From: Andrew Wood <Andrew.Wood@arun.gov.uk>
Sent: 16 July 2021 14:34
To: Planning.Responses <Planning.Responses@arun.gov.uk>
Subject: FW: FW: LU/131/21/DOC - more information required 125 Bayford Road conditions discharge.

'4 No part of the development shall be first occupied until an electric vehicle charging space has been provided in accordance with plans and details to be submitted to and approved by the Local Planning Authority. That facility agreed shall be permanently retained. Reason: To provide sustainable travel options in accordance with policy T SP1 of the Arun Local Plan.'

Subject: LU/131/21/DOC - more information required 125 Bayford Road conditions discharge.

Proposed Site Plan plan 1:100

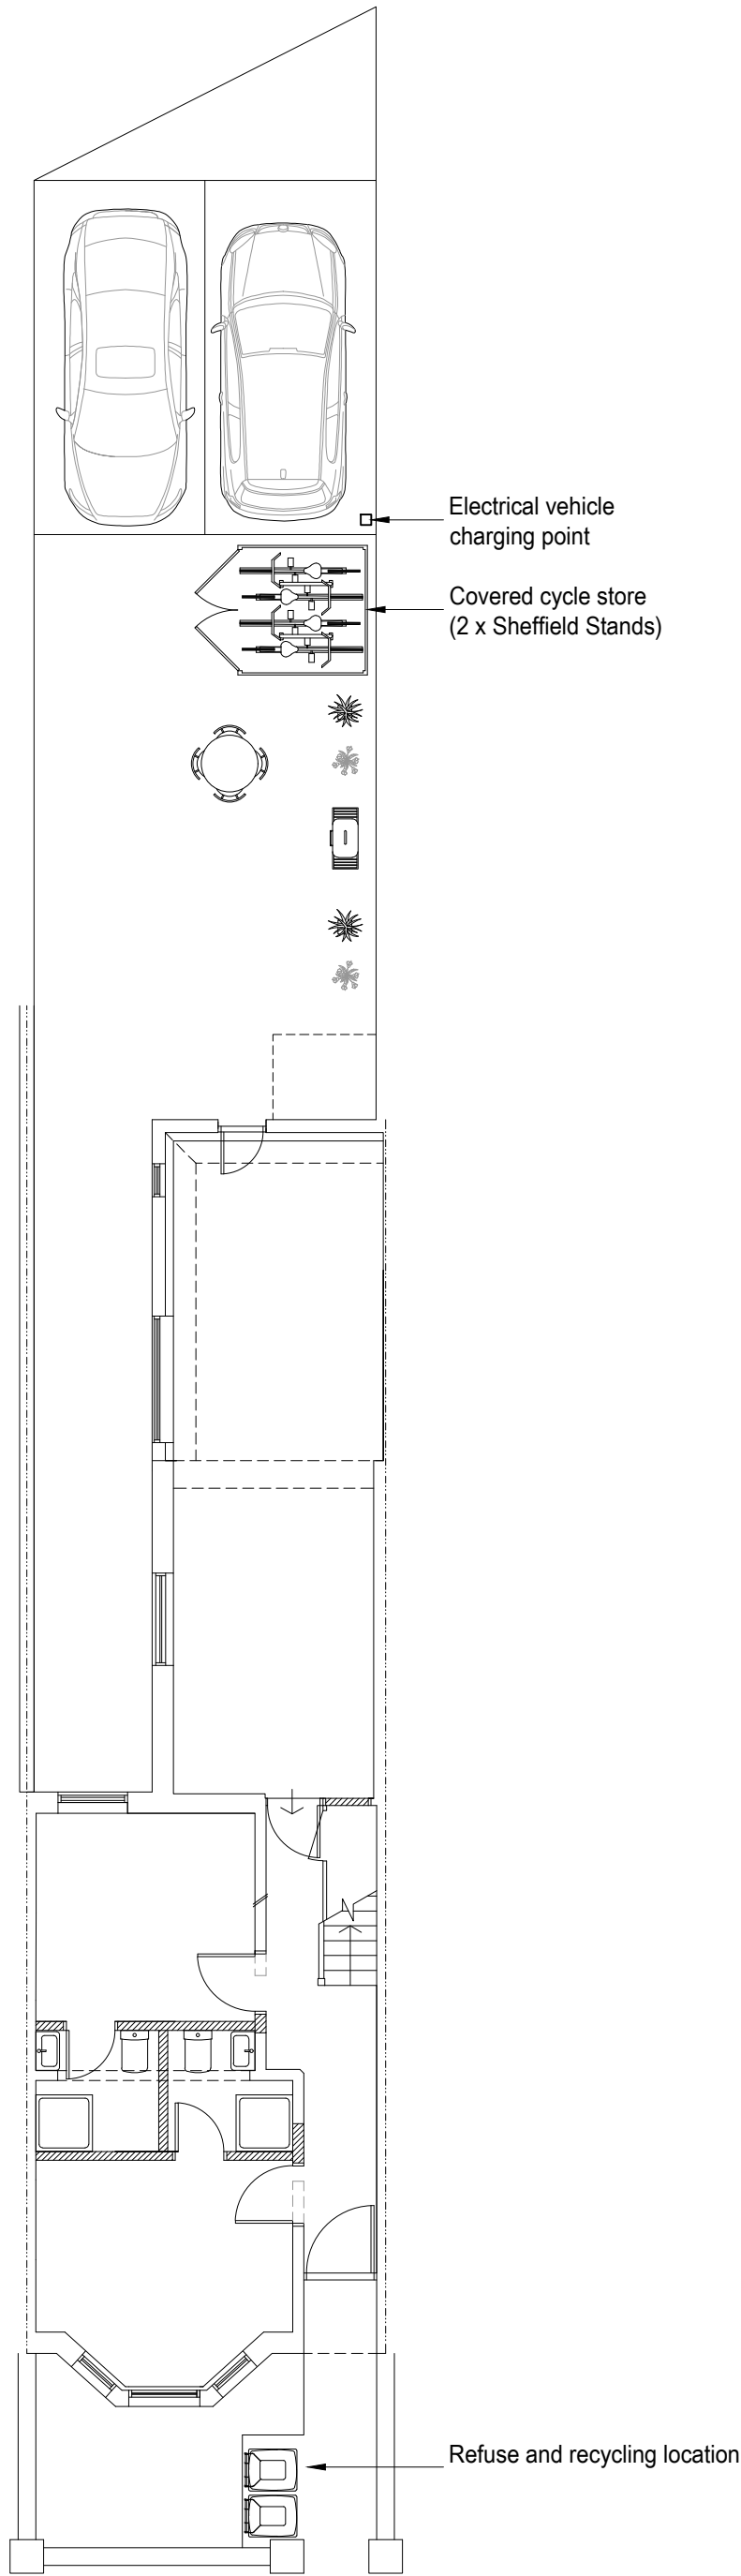
2 charging points rather than one.

So we have met the requirements of the condition by proposing one EV point. We are not required to provide two.

Unit shown: WALLPOD:EV
HOMESMART EV
Type 2, Mode 3 Charging Socket

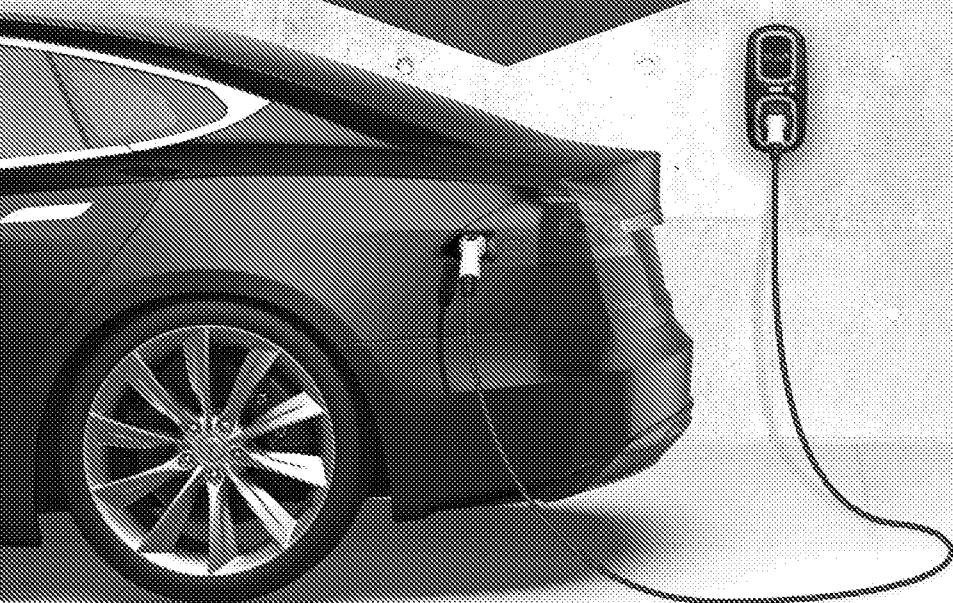
IS this specification ok for you? pls see attached document.

Specification sheet for ev charge points .

Yes the specification is acceptable,
